Please ask for: Ms Iqraa Malik
Email: iqraa.malik@terraquest.co.uk
Telephone: 01212341390
Our Ref: A/83/21/HH
Your Ref:
Date: 28th April 2021

Application for Planning Permission for Works or Extension to a Dwelling

Development: Installation of replacement fencing along the boundary with Station Road
Location: North Lodge North Drive Angmering BN16 4JJ

Site Plan

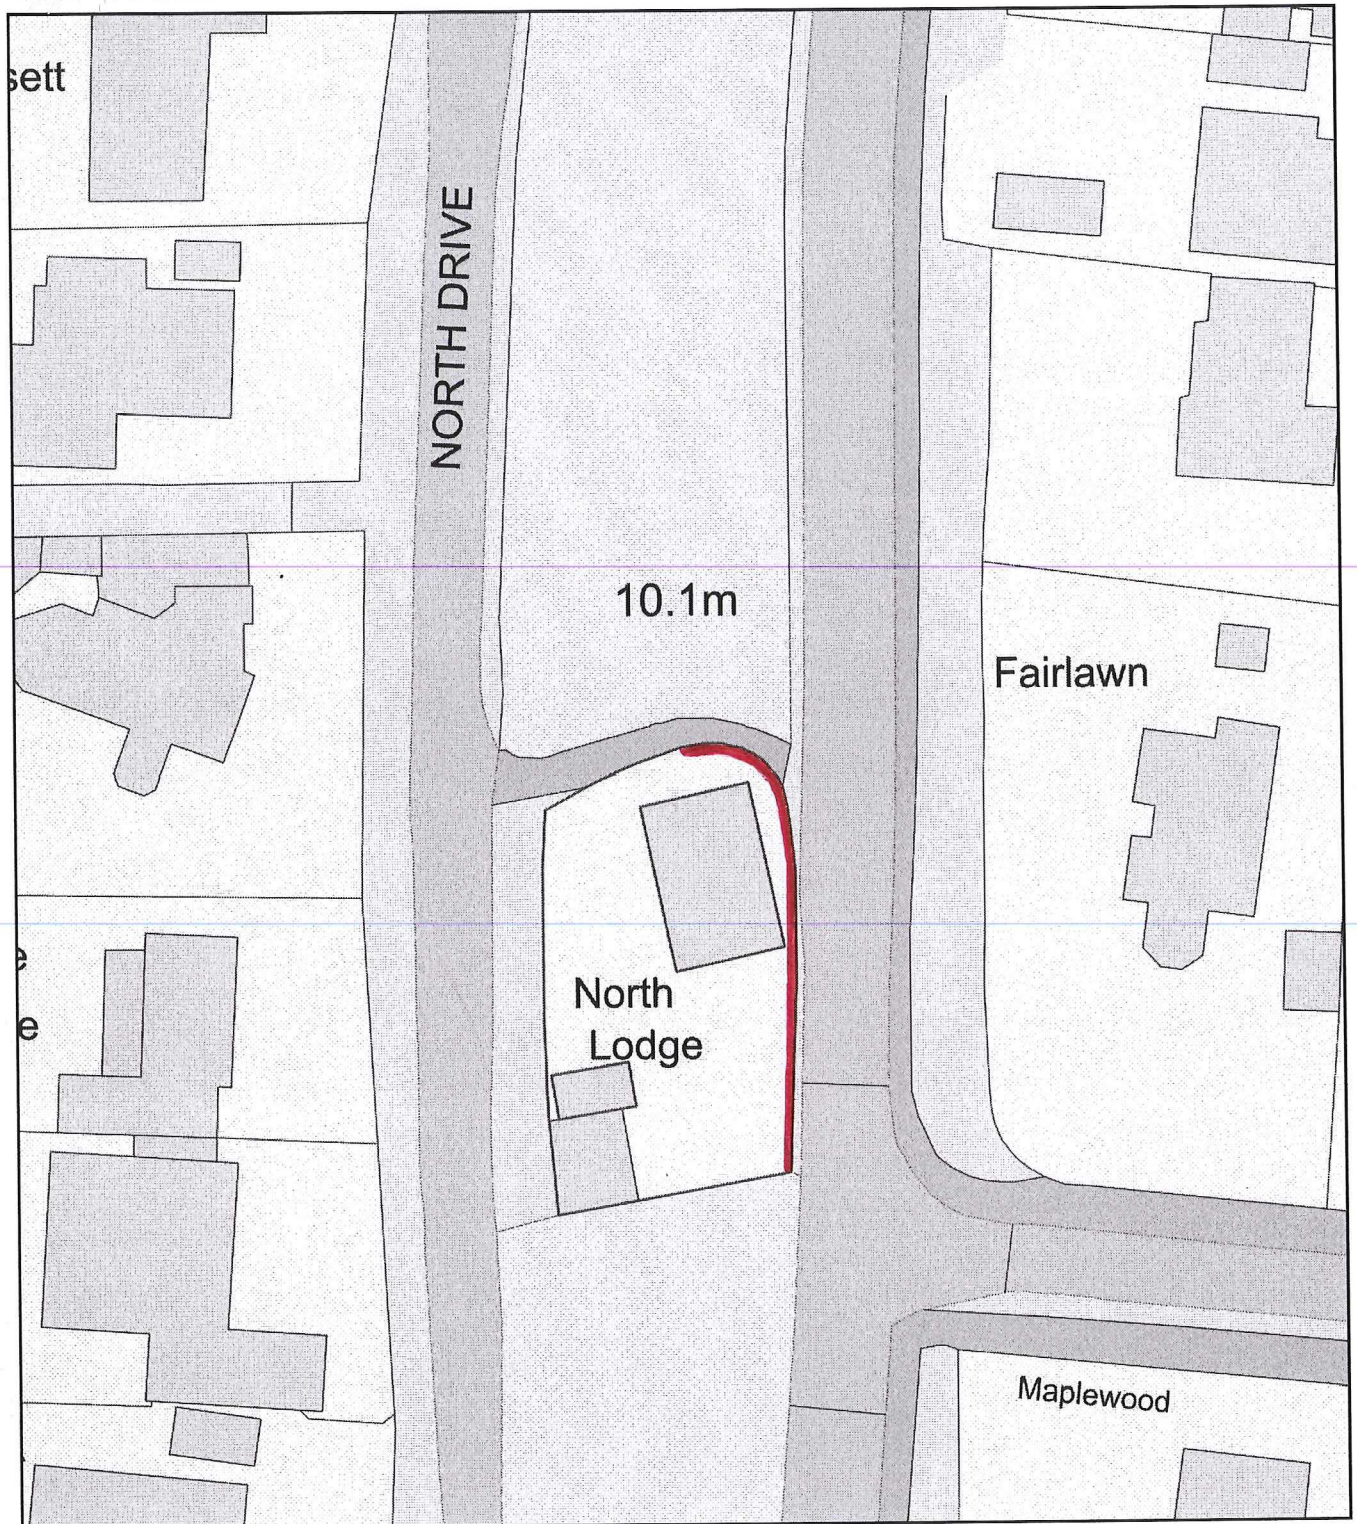
Location Plan and Block Plan

The location and block plan require one solid red outline around the site, the one currently submitted has two red outlines please amend. Further details of what must be included on the plan can be found in the Validation Requirements List.

Timber fencing

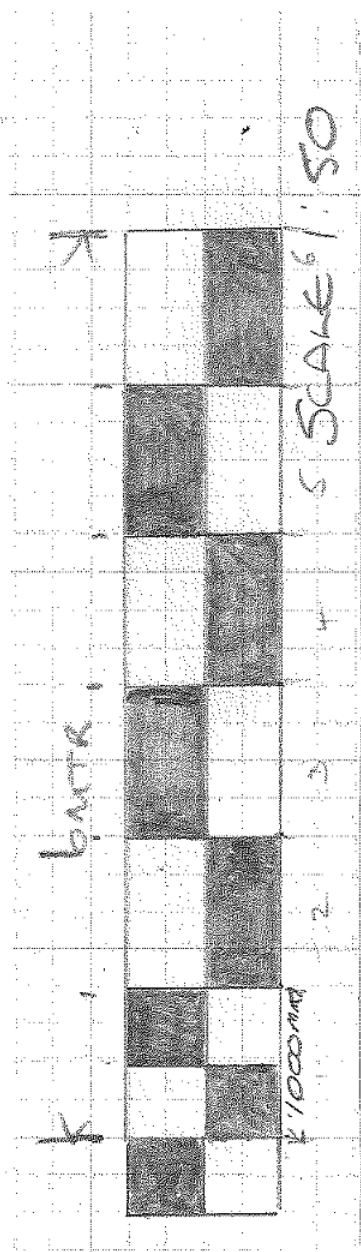
Elevations

Please submit 1 electronic or 3 paper copies of clearly labelled fence elevations at a scale of 1:50 or 1:100. Further details can be found in the Validation Requirements List.
